Recommendation Report for Lawful Development Certificate for a Proposed Use or Development

REF NO: LU/89/21/CLP

LOCATION: 25 Amberley Close
Littlehampton
BN17 6HW

PROPOSAL: Lawful development certificate for a proposed single storey side extension.

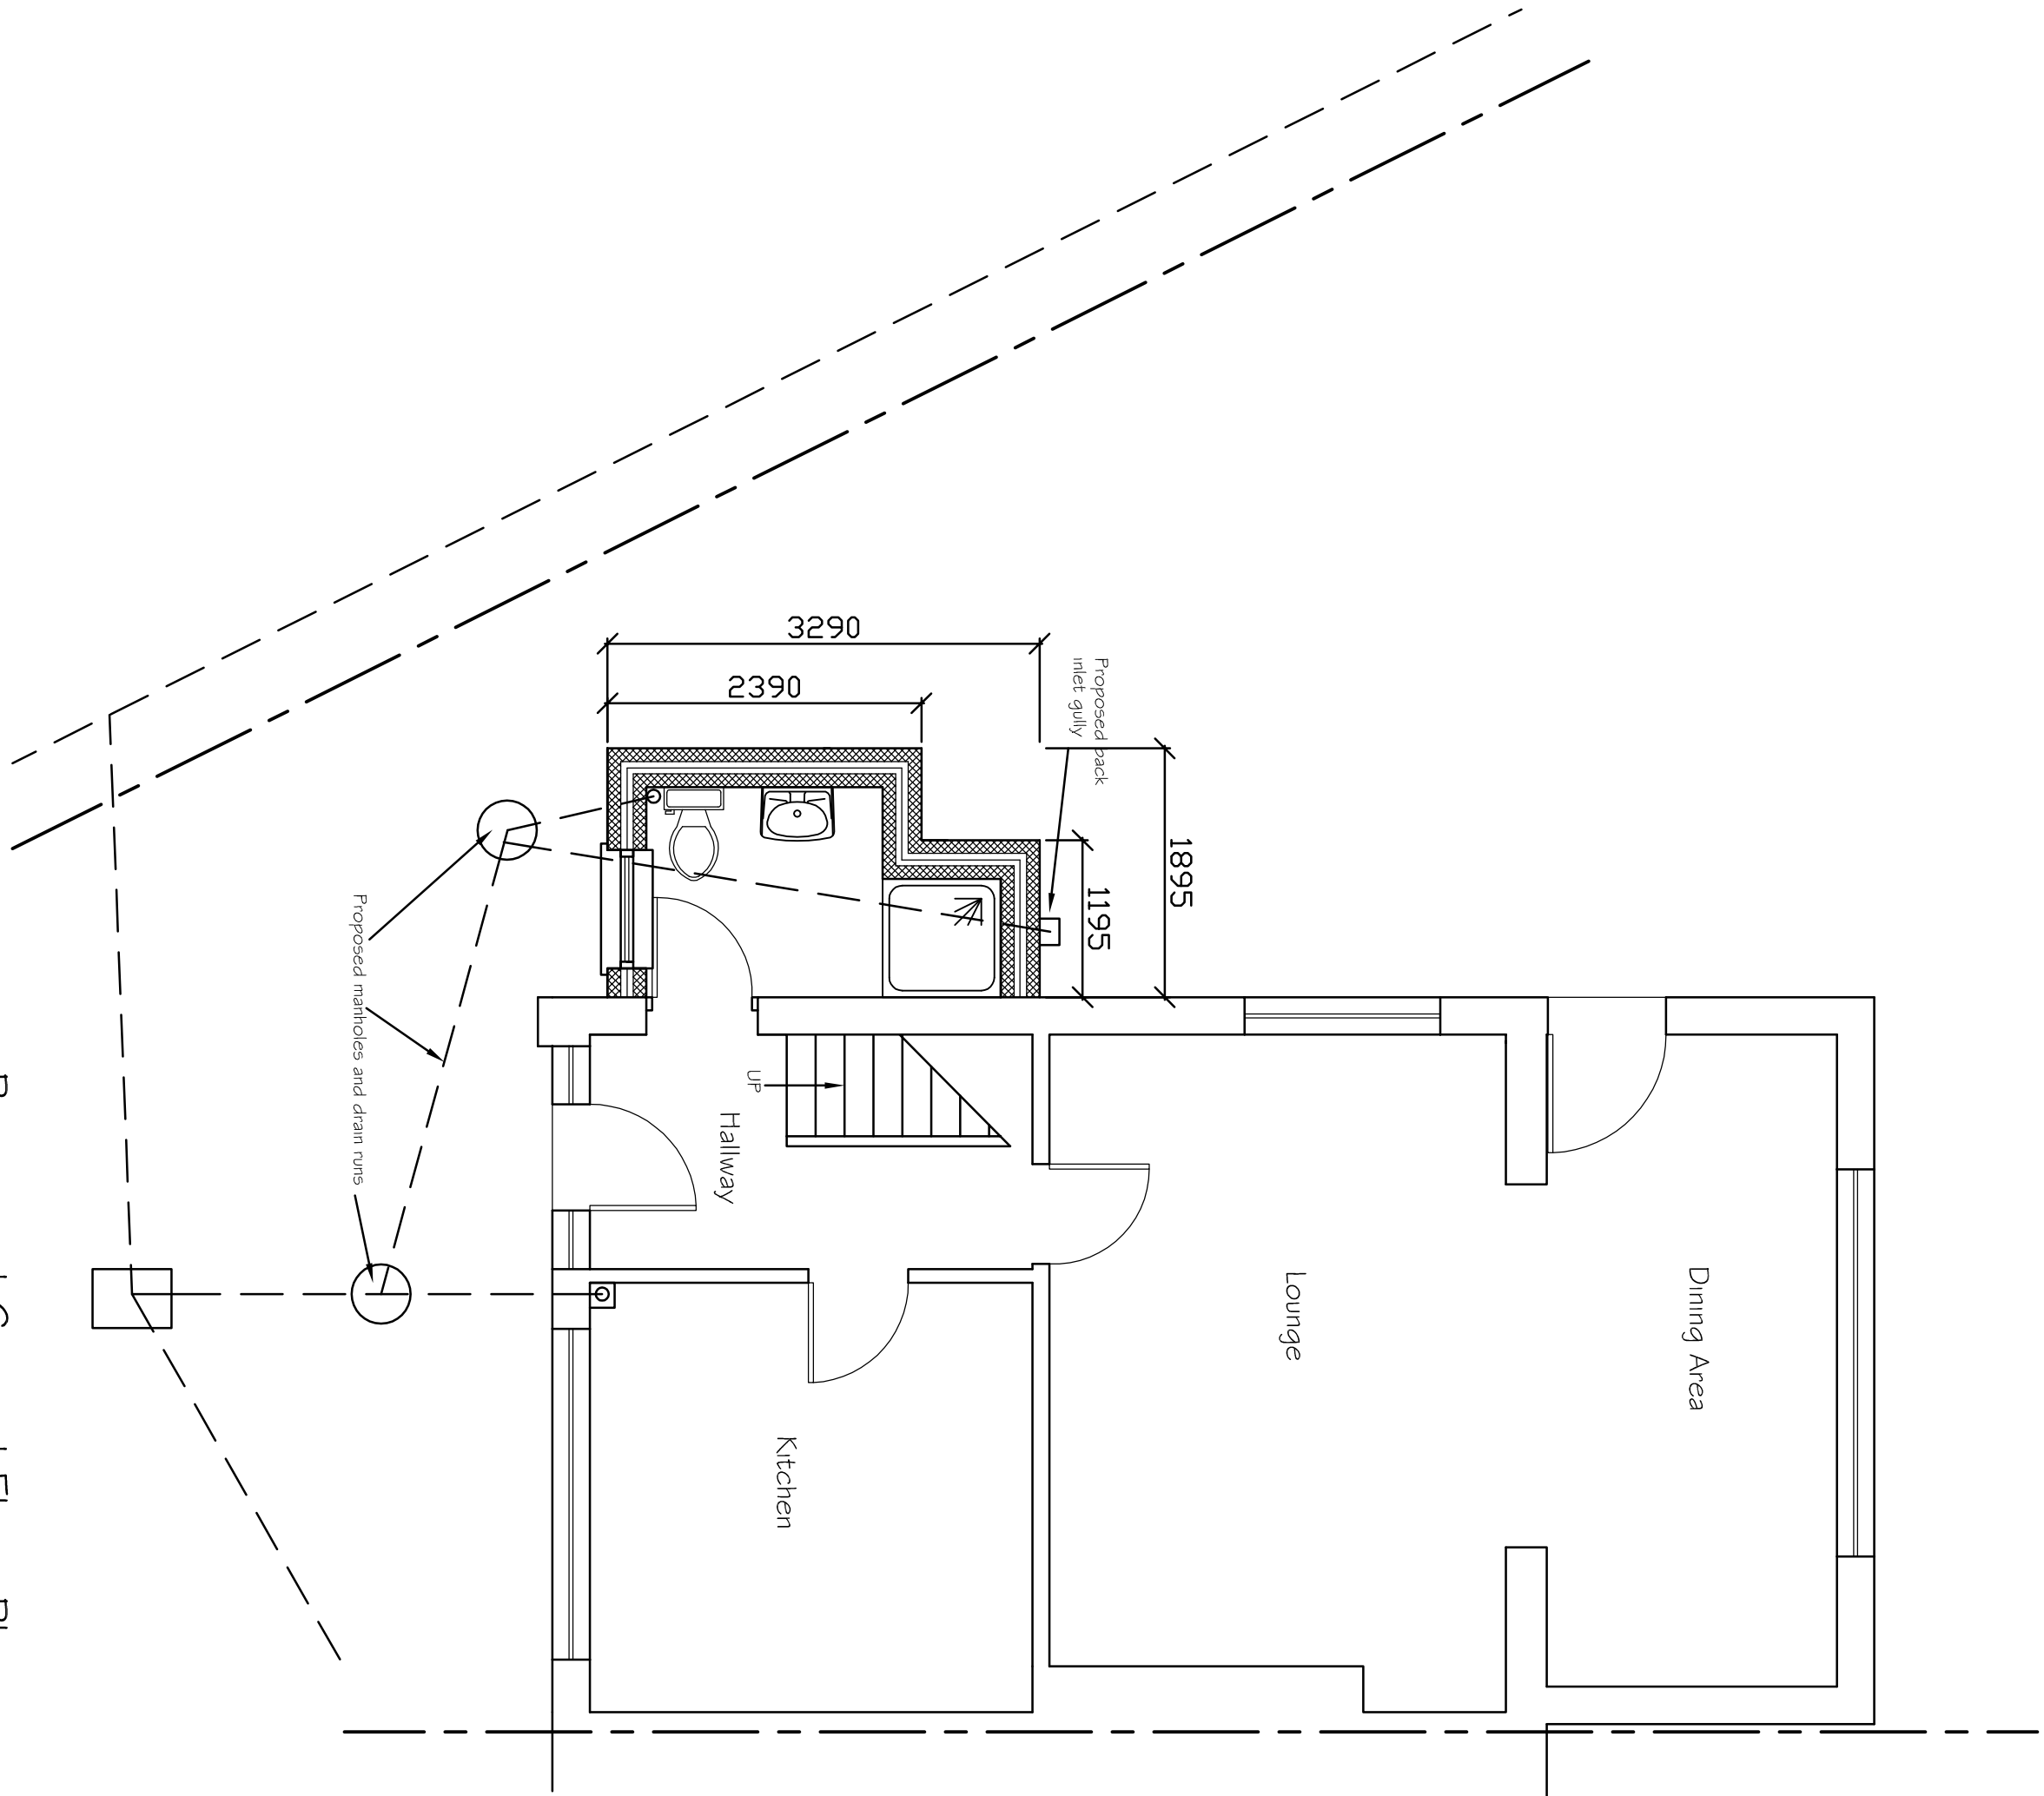
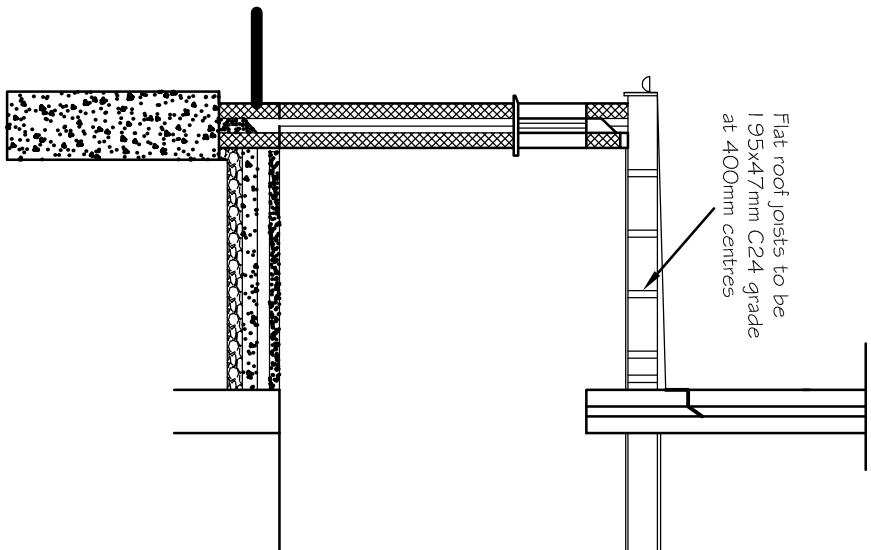
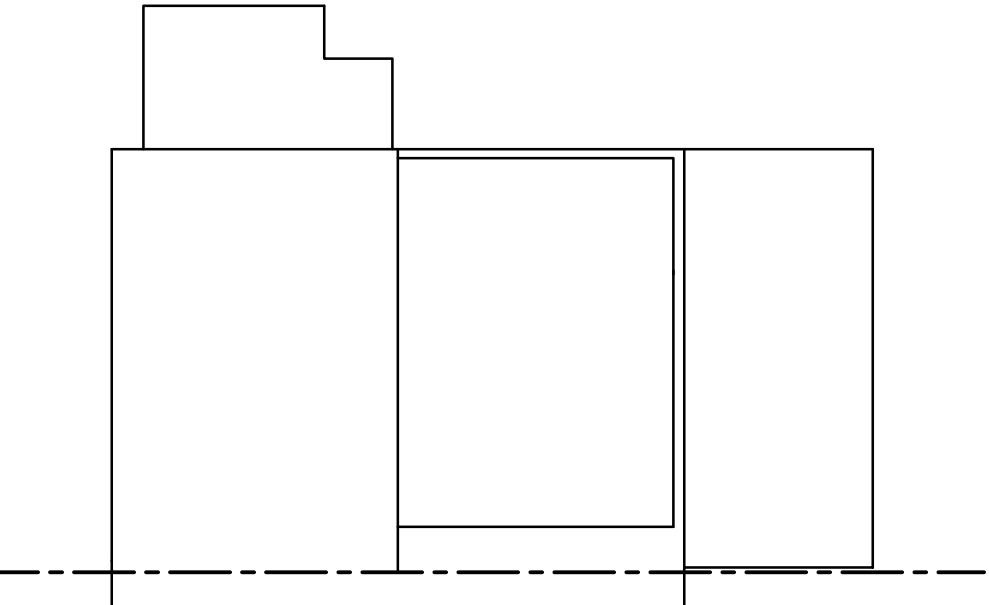
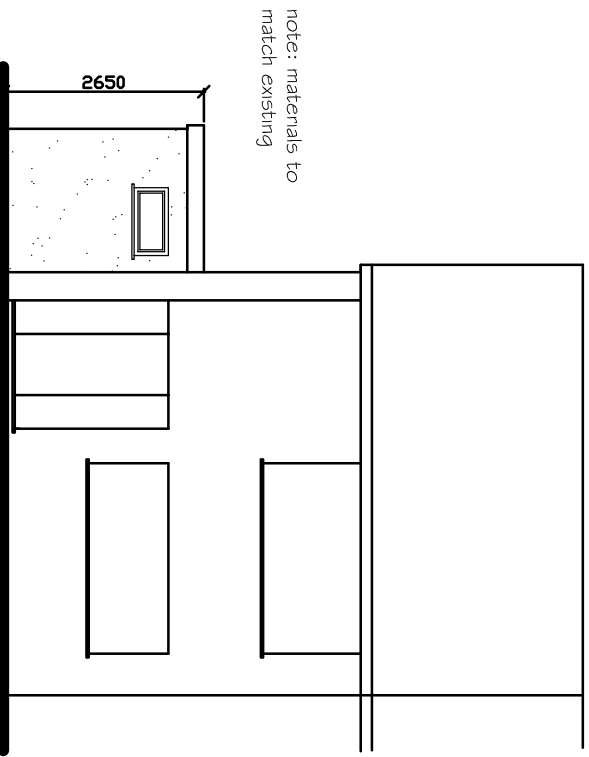
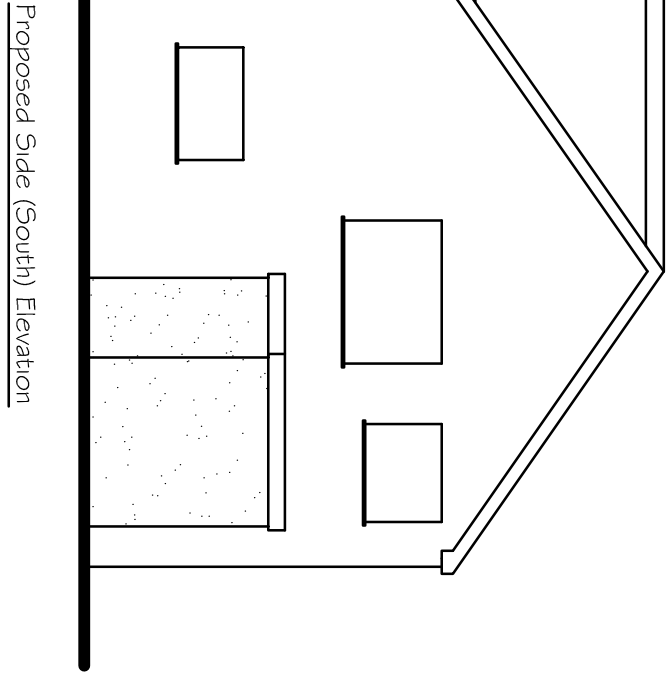
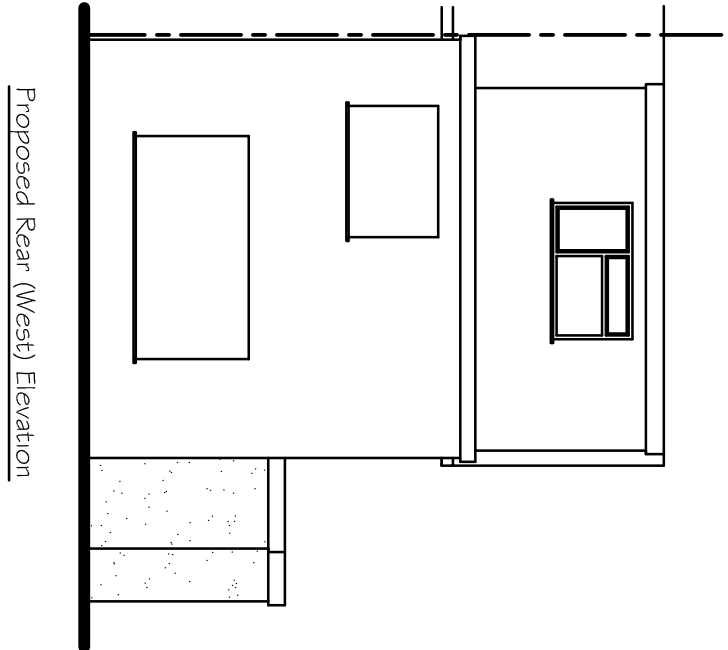
It would not exceed 50% of the total area of the curtilage.

It would not exceed the highest part of the roof.

It would not exceed the eaves height of the dwellinghouse.

It would not.

It would extend to the side only.

It would not have more than a single storey

- i) the enlarged part of the dwellinghouse would be within 2 metres of the boundary of the curtilage of the dwellinghouse, and the height of the eaves of the enlarged part would exceed 3 metres;
The height of the eaves would not be more than 3 metres,

It would not exceed 4 metres in height , be of more than a single storey or have a width greater than half the width of the original dwellinghouse.

The materials of construction are to match that of the existing dwellinghouse..

The side extension is considered to comply with relevant parts of Class A of the GDPO and as such is considered permitted development and does not require the submission of an application for full planning permission.
